COMMUNITY DEVELOPMENT DEPARTMENT
501 Delta Ave ♦ Marysville, WA 98270
(360) 363-8100

Re: Hsiao Short Plat – *Technical Review 2*
File #SP22-004

RE: Hsiao Short Plat, File# SP22-004
Preliminary Short Subdivision of 1.14 acres into five (5) single-family detached lots
4100 81st Place NE & Parcel # 00550600001200, 00550600001300, 30052100314700

SEWER & WATER PLAN

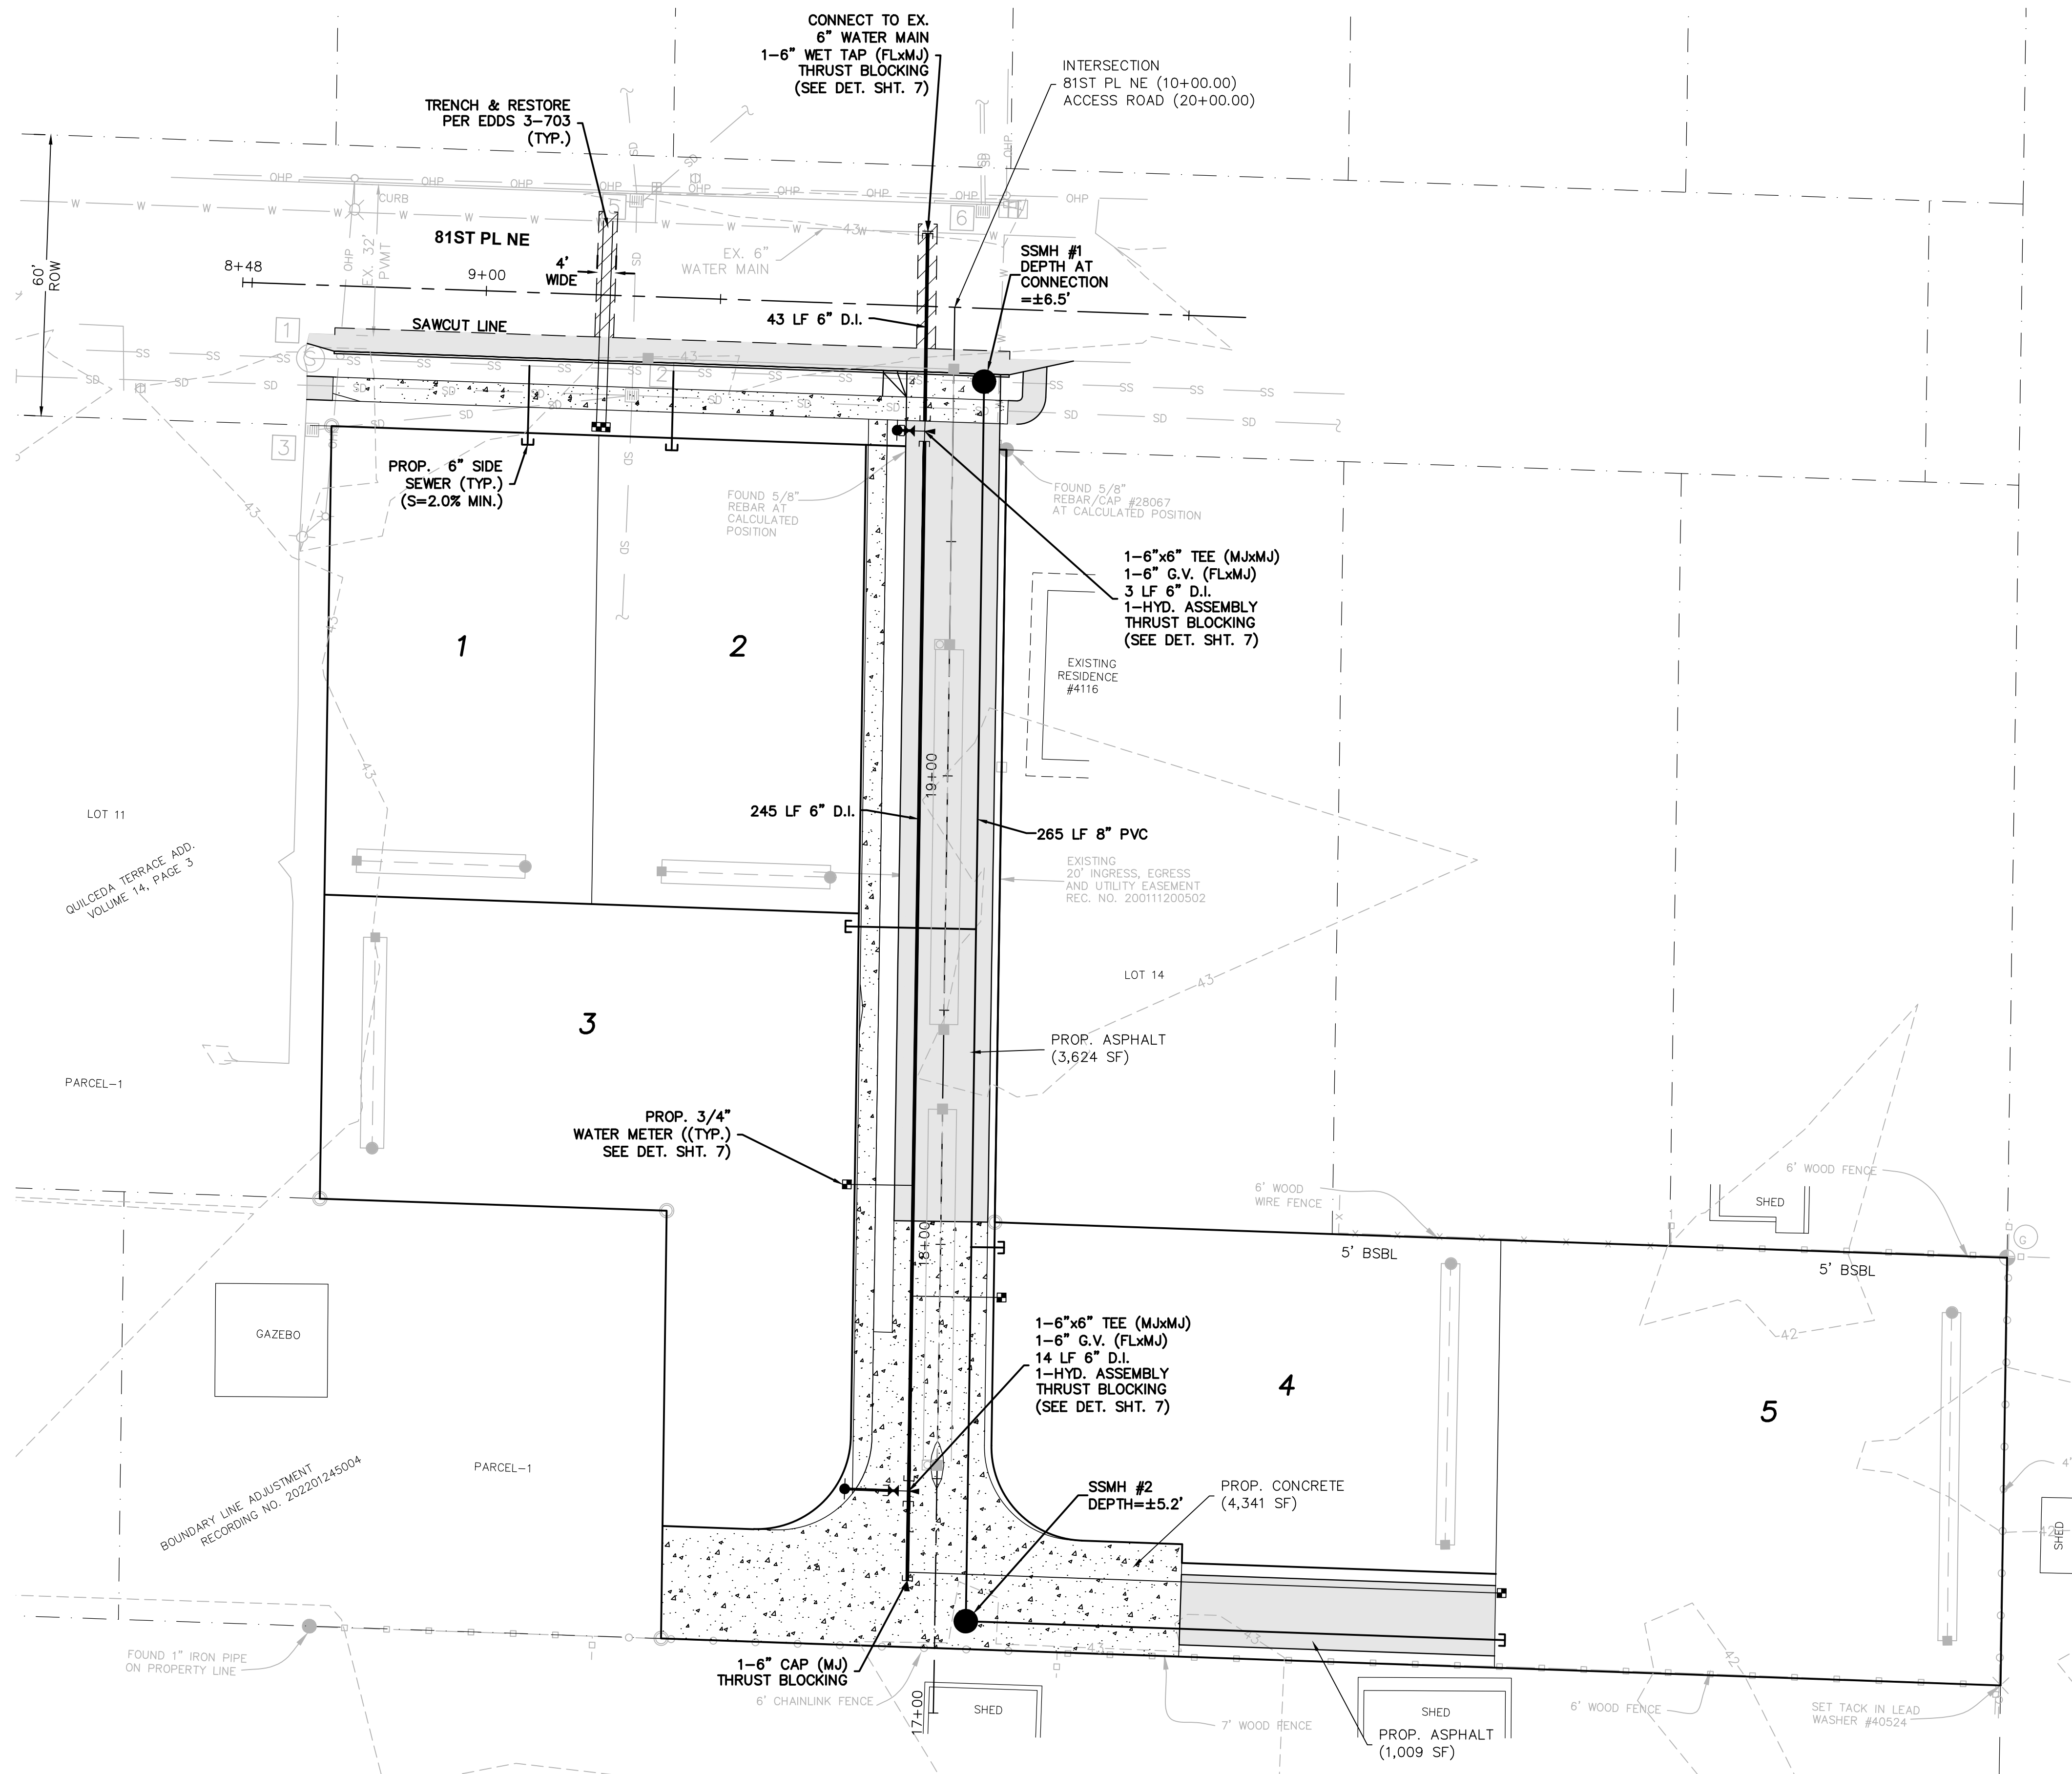
- i. The water main will need to be 8" and the end of the water main will require a blow off assembly. Please also move the hydrant located at the corner of the private road and 81st PL NE behind the sidewalk.

1. Water main needs to be 8" as opposed to proposed 6" in accordance with Design and Construction Standards 2-050 part C;
2. End of water main will require a 2" blow off assembly in accordance with Design and Construction Standards 2-050 part C;
3. Wet tap water main tie in on 81st PI Ne needs a gate valve on new water main, tapping tee is not currently shown;
4. Terminate meter for Lot 5 at the end of the concrete on side of asphalt, this will require tap to be moved slightly north to allow for perpendicular installation.
5. Water Comp Plan item #306 is listed as High Priority and lists 1954 6" cast iron water main on 81st PI be upsized to 8" ductile iron.

81ST PLACE SHORT PLAT
SP22-004

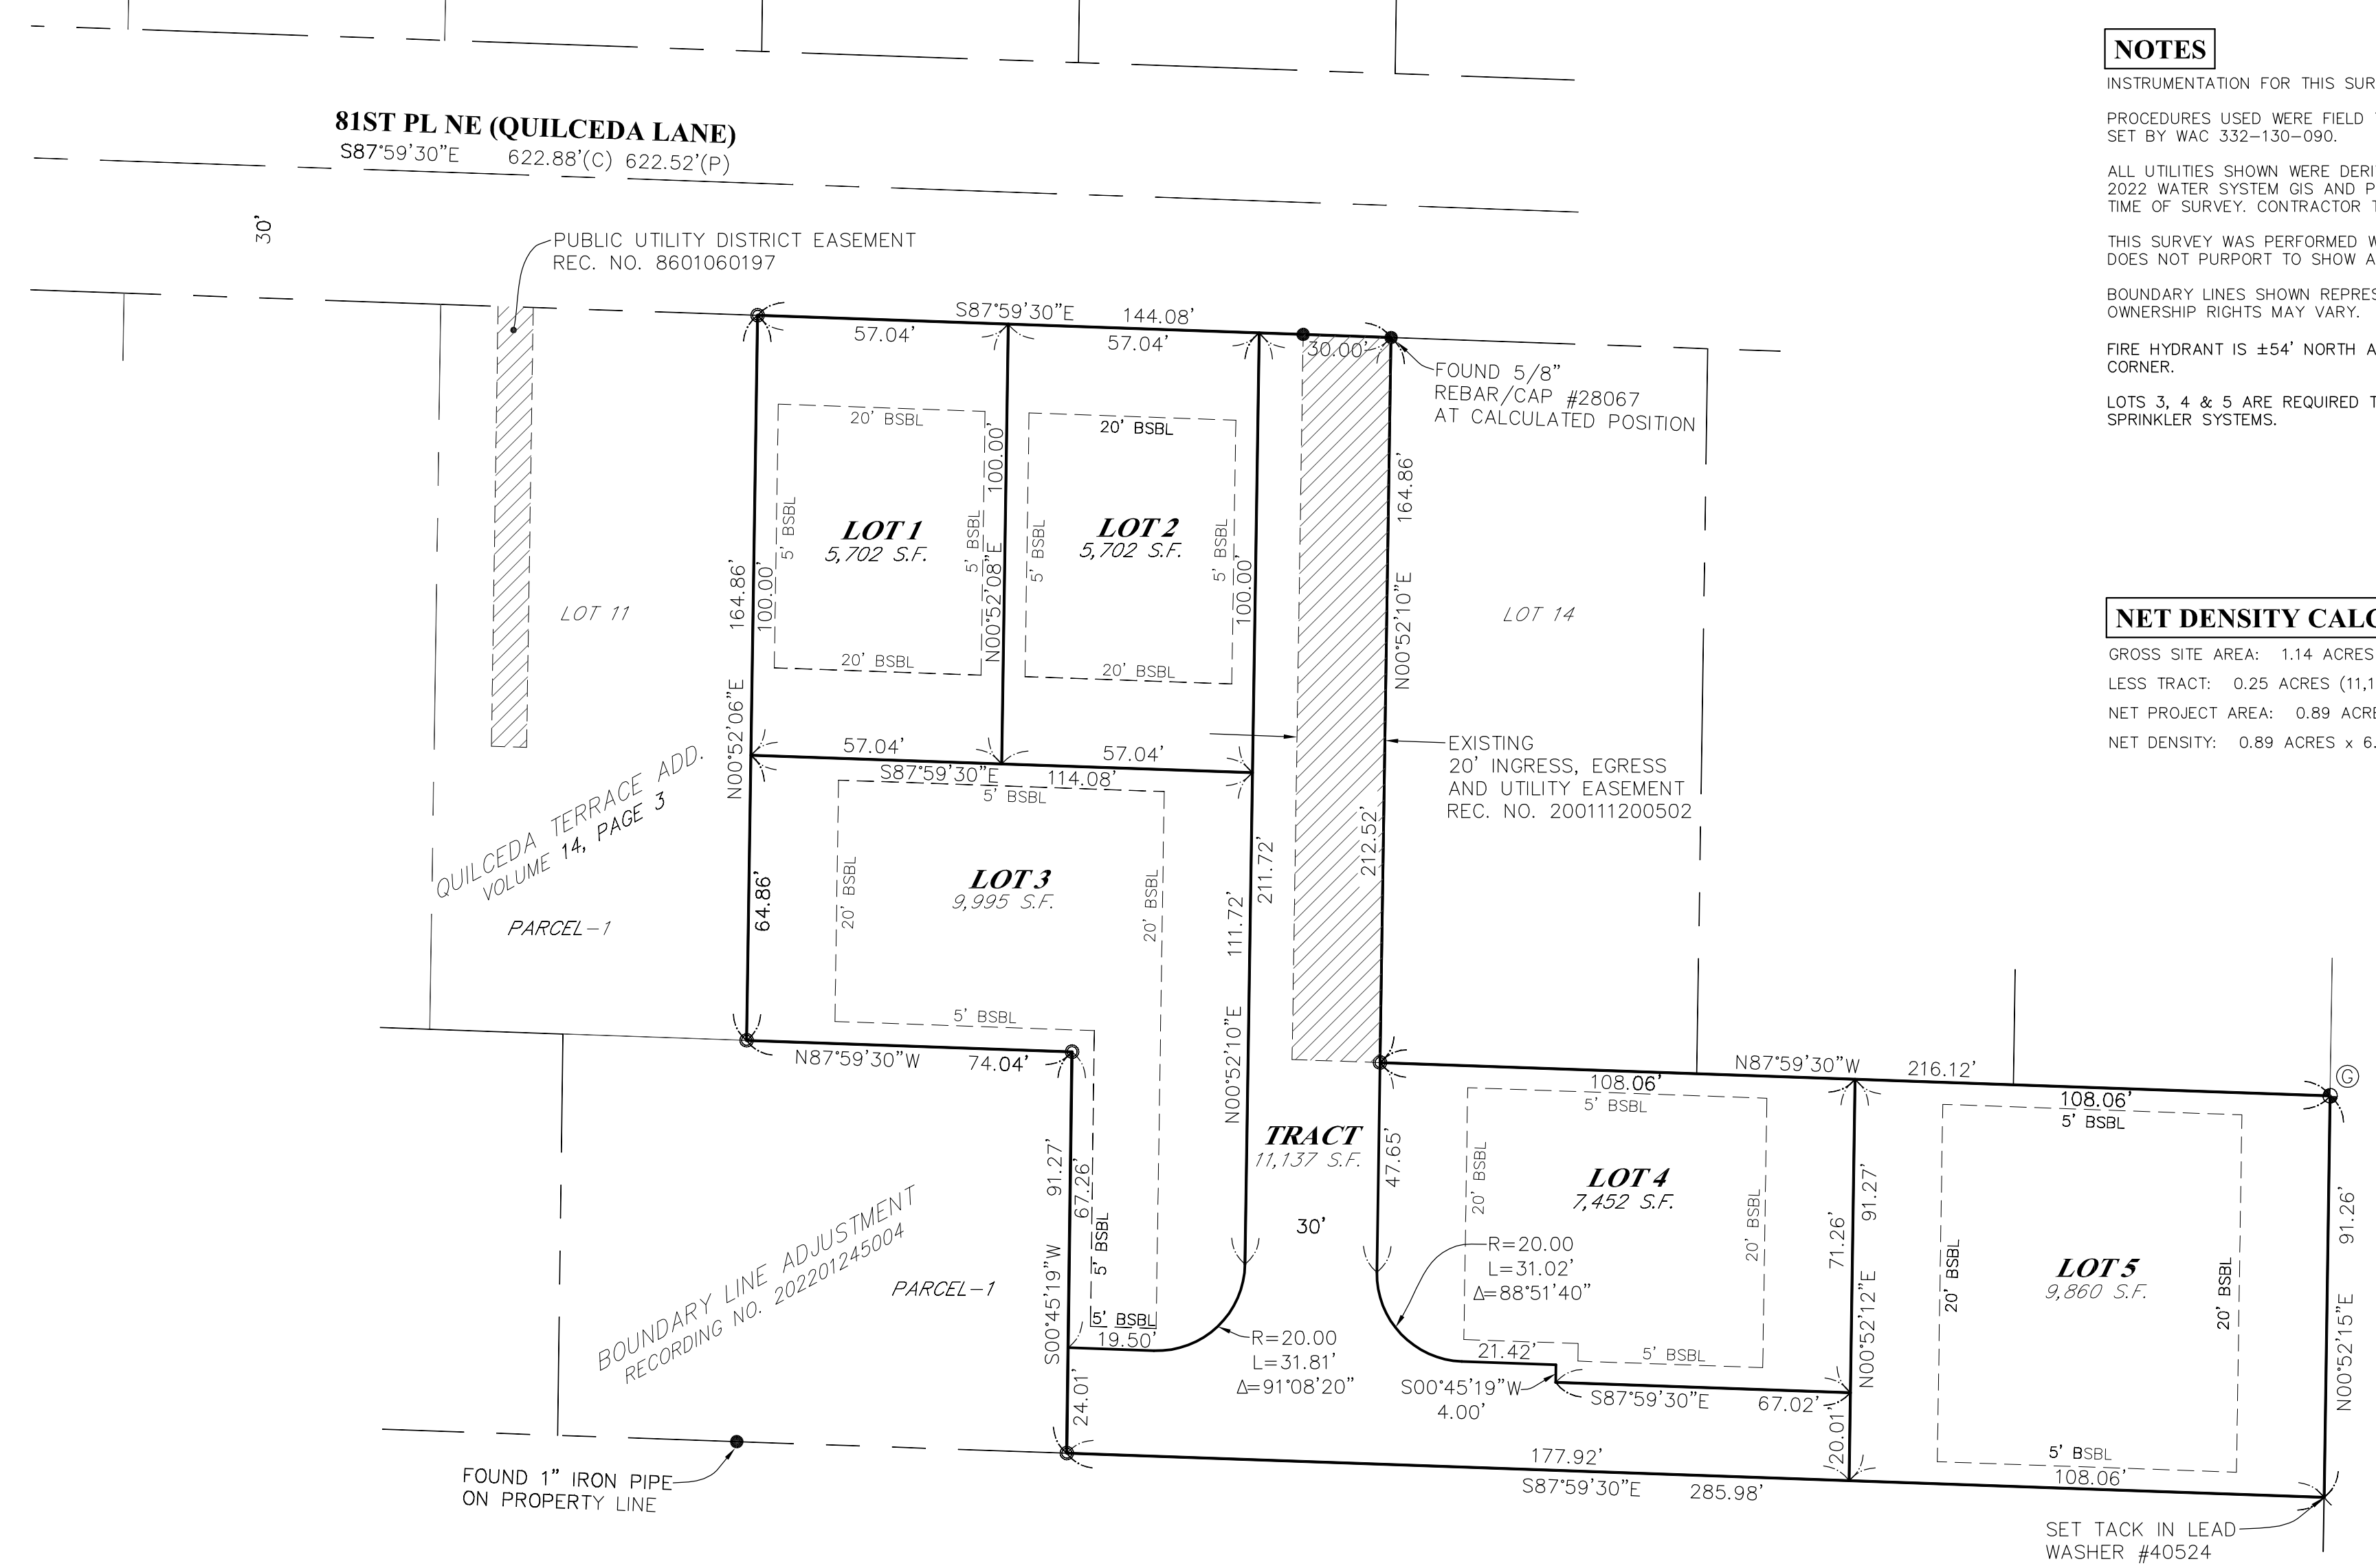
1. The portion of lot 3 extending to the south is not buildable. For clarity, only depict setbacks on the upper portion of lot 3.

5. Extinguish 20' ingress/egress and utility easement under AFN 20011200502.
